Your Ref: OWPC21894
Our Ref: BR/49/19/OUT 13-02-2019
Please ask for:
Mr S Davis

Outline application with all matters reserved for 22 No. new dwellings consisting of 2 No. 1 bed dwellings, 18 No. 2 bed dwellings & 2 No. 3 bed dwellings.

26 Burnham Avenue Bognor Regis

Thank you for your internet representation made on 29th March 2019 which has been recorded as '**an objection**' with the comments as follows:

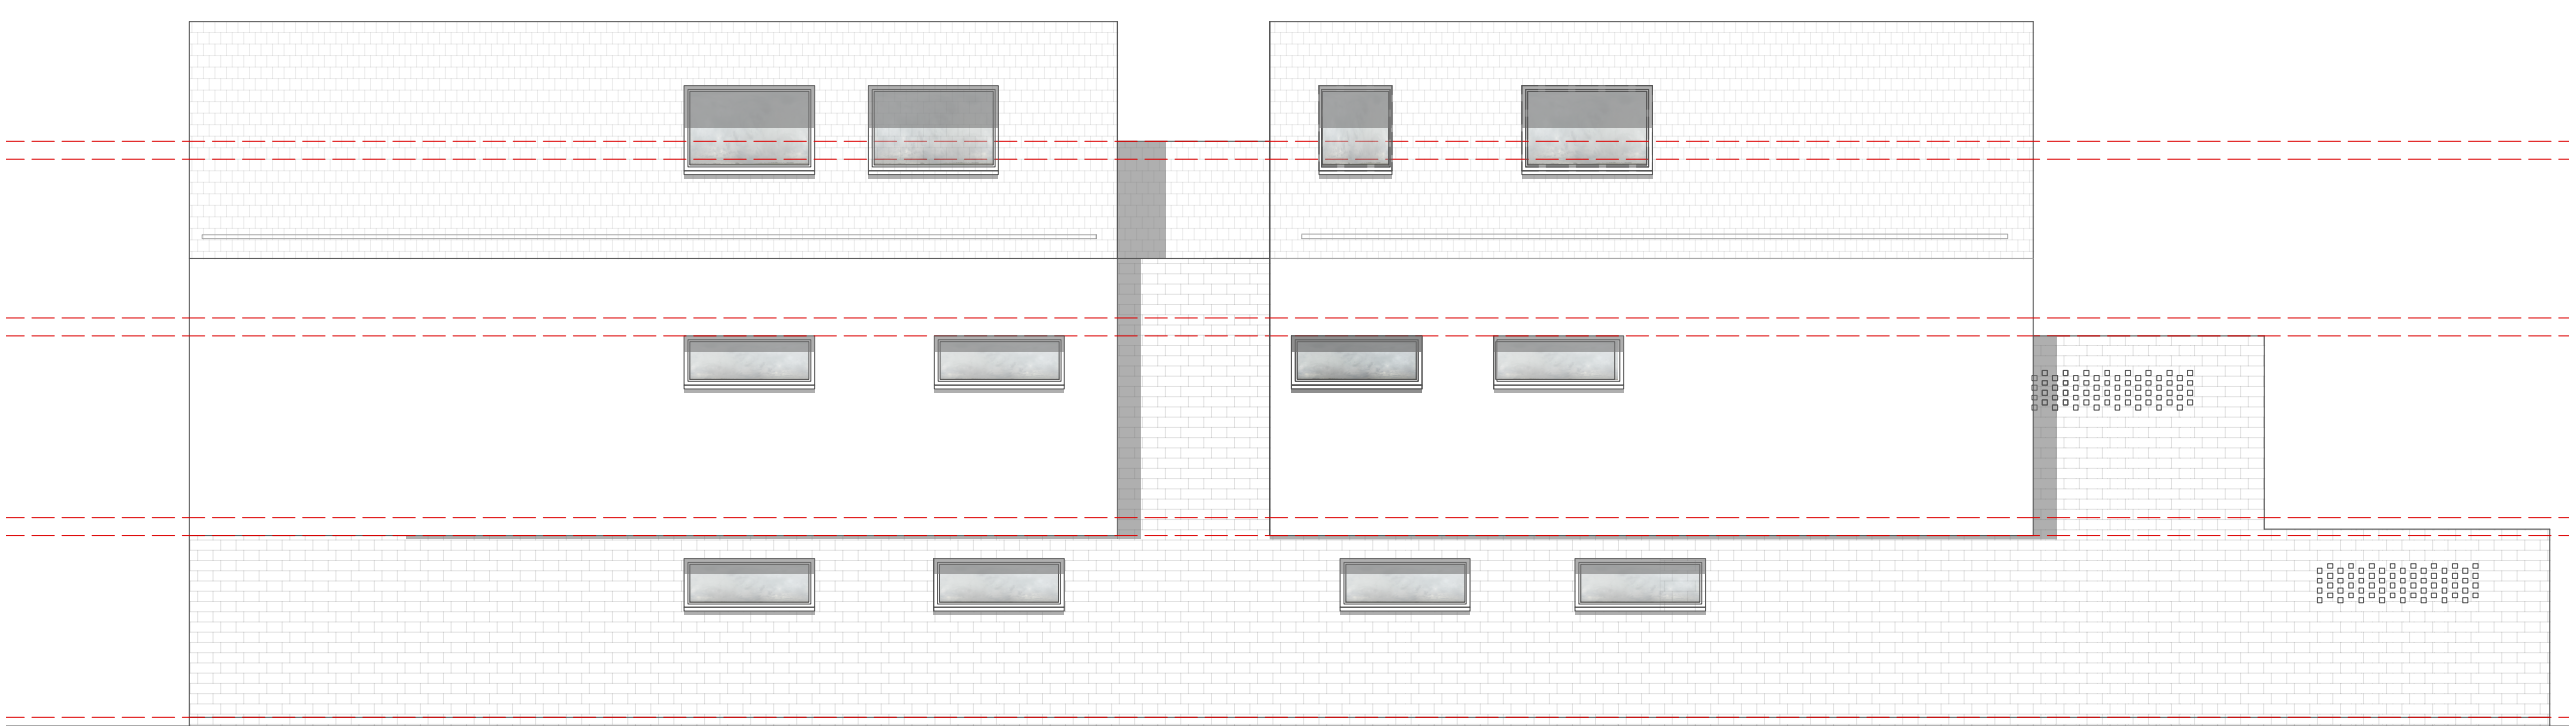
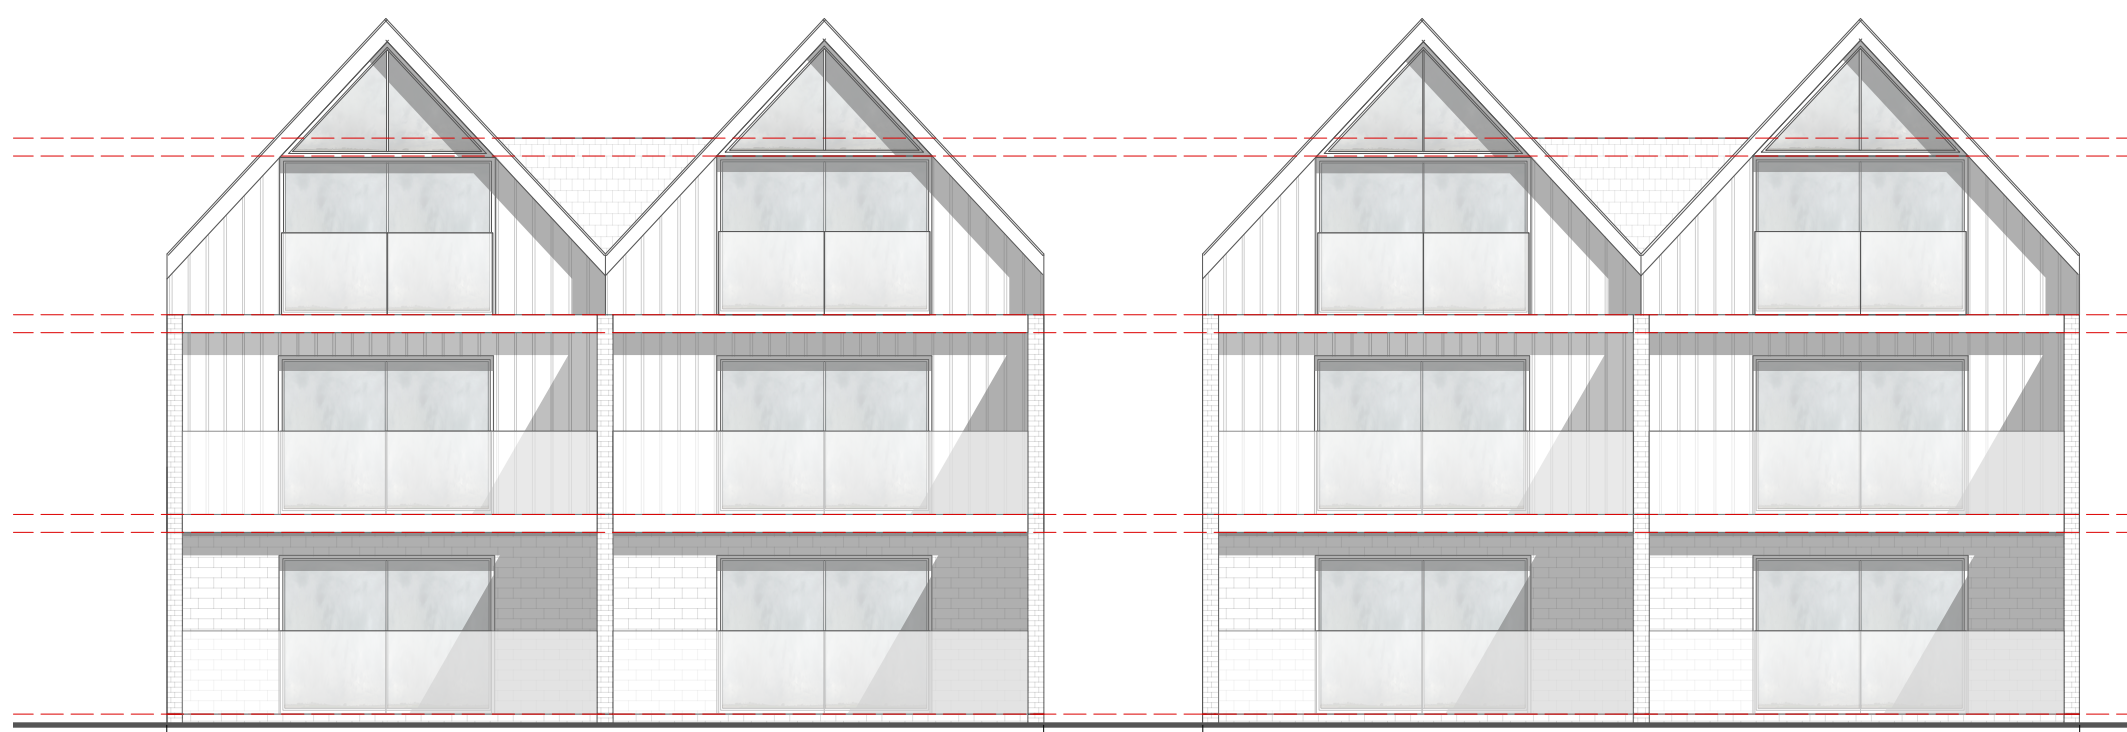
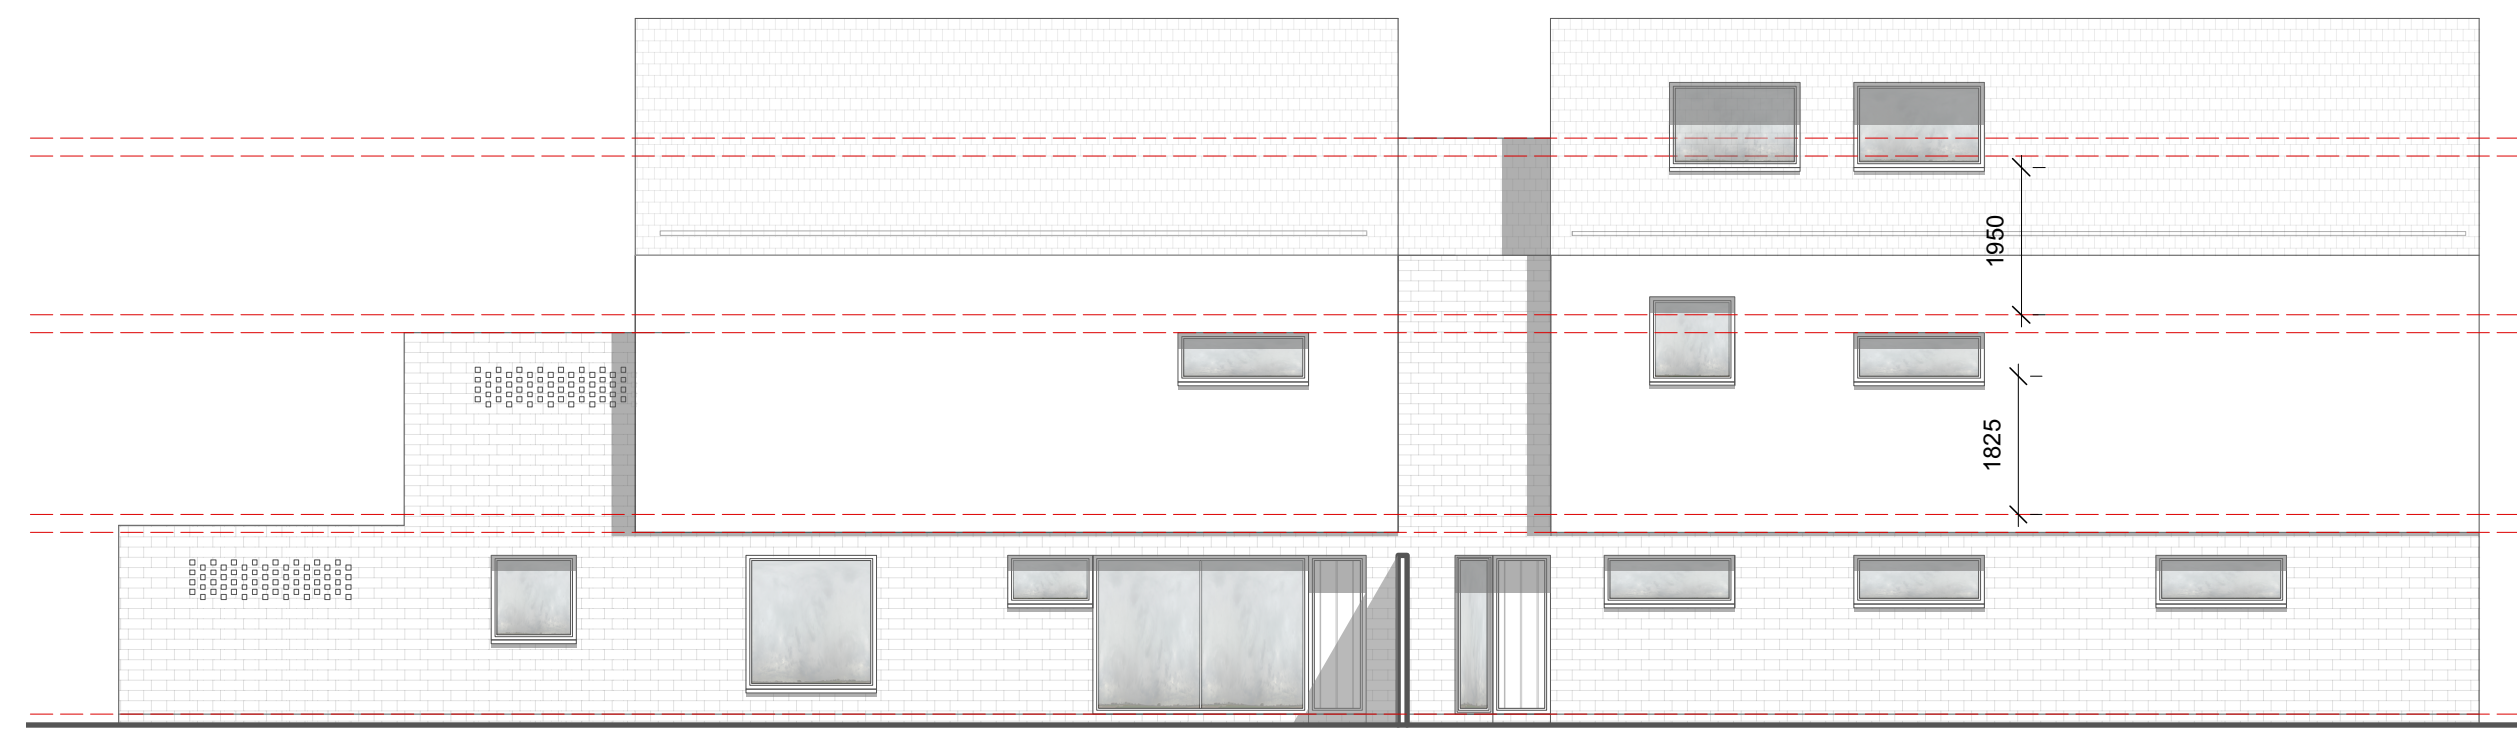
The impact on neighbouring dwellings, especially those to the rear in Burnham Gardens would be enormous. They would lose privacy, light, air, space and would be totally overlooked by this development.
